From: Contact Centre (CRM) <contact@ribblevalley.gov.uk>
Sent: 16 March 2026 10:31
To: Planning
Subject: Planning Application Comments - 3/2026/0144 FS-Case-813146129

Planning Application Reference No.: 3/2026/0144

Address of Development: Read Cricket and Bowling Club Whalley Road Read BB12 7PN

Client Read Cricket Club		
Project Proposed Ball Stop Nets at Read Cricket and Bowling Club Whalley Road Read BB12 7PN		
Drawing Title Proposed Ball Stop Nets Plan and Existing / Proposed Elevations		
Scale 1:100/200 @ A1	Date Nov 2025	Drawn LFR
READ DESIGN LTD		
174 - 03

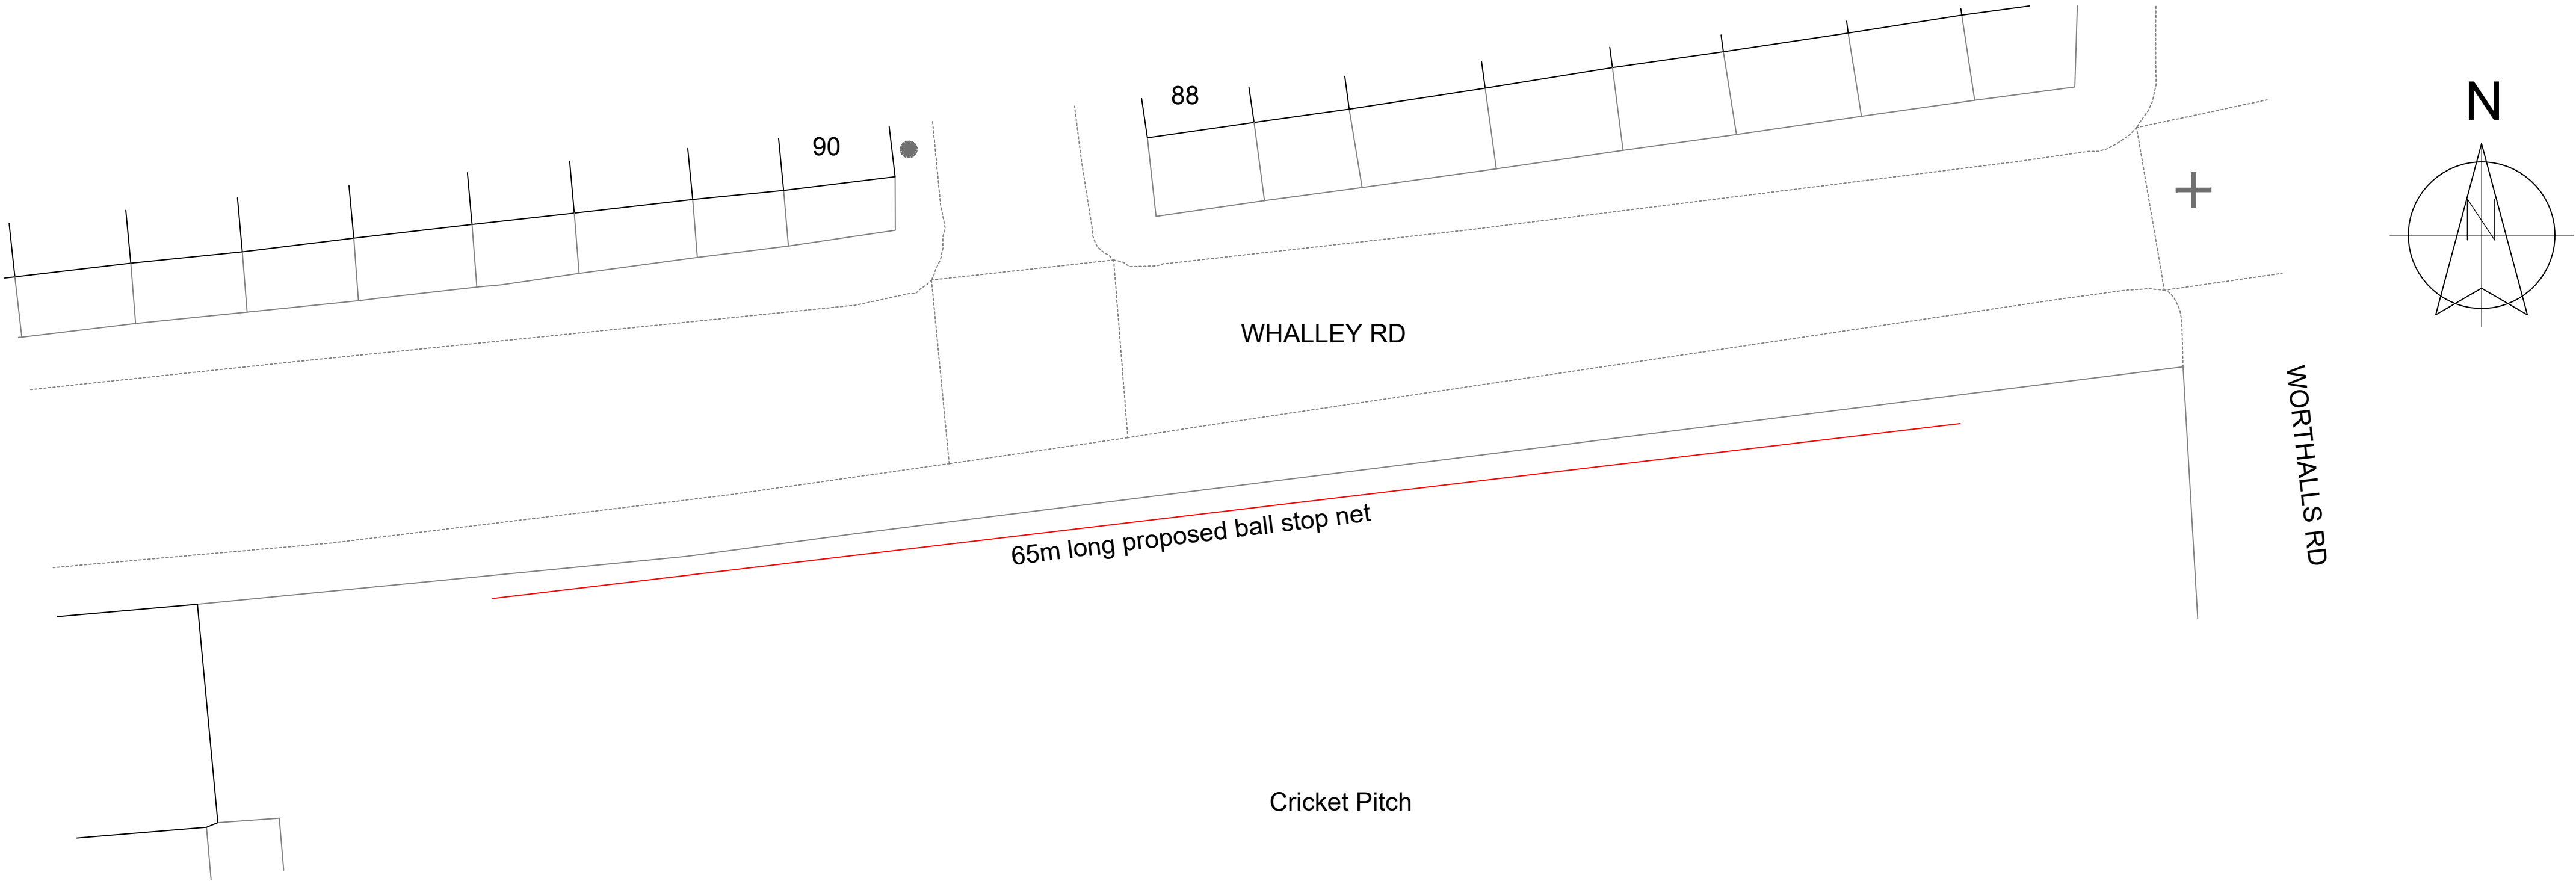
Comments: I am very disappointed to read this planning application for a semi-permanent ball net. The proposal places it less [REDACTED], with 11m poles that, by the sound of things, will remain as a permanent fixture. This will leave large poles standing [REDACTED] [REDACTED] will undoubtedly have a negative impact on both the outlook and the value of my property.

The application states that the net itself will be erected for around six months of the year and will stand approximately 8m high. From my perspective this will [REDACTED] and [REDACTED] [REDACTED] I have been a resident here for [REDACTED] and during that time I have never had any issues with balls [REDACTED]. There has been no damage to my property, vehicles, or anything within my garden.

While I understand the intention of preventing balls leaving the ground, the scale and permanence of what is proposed seems excessive given the lack of any known issues affecting neighbouring properties. It would be disappointing to see such a dominant structure introduced into what has historically been an open outlook for residents.
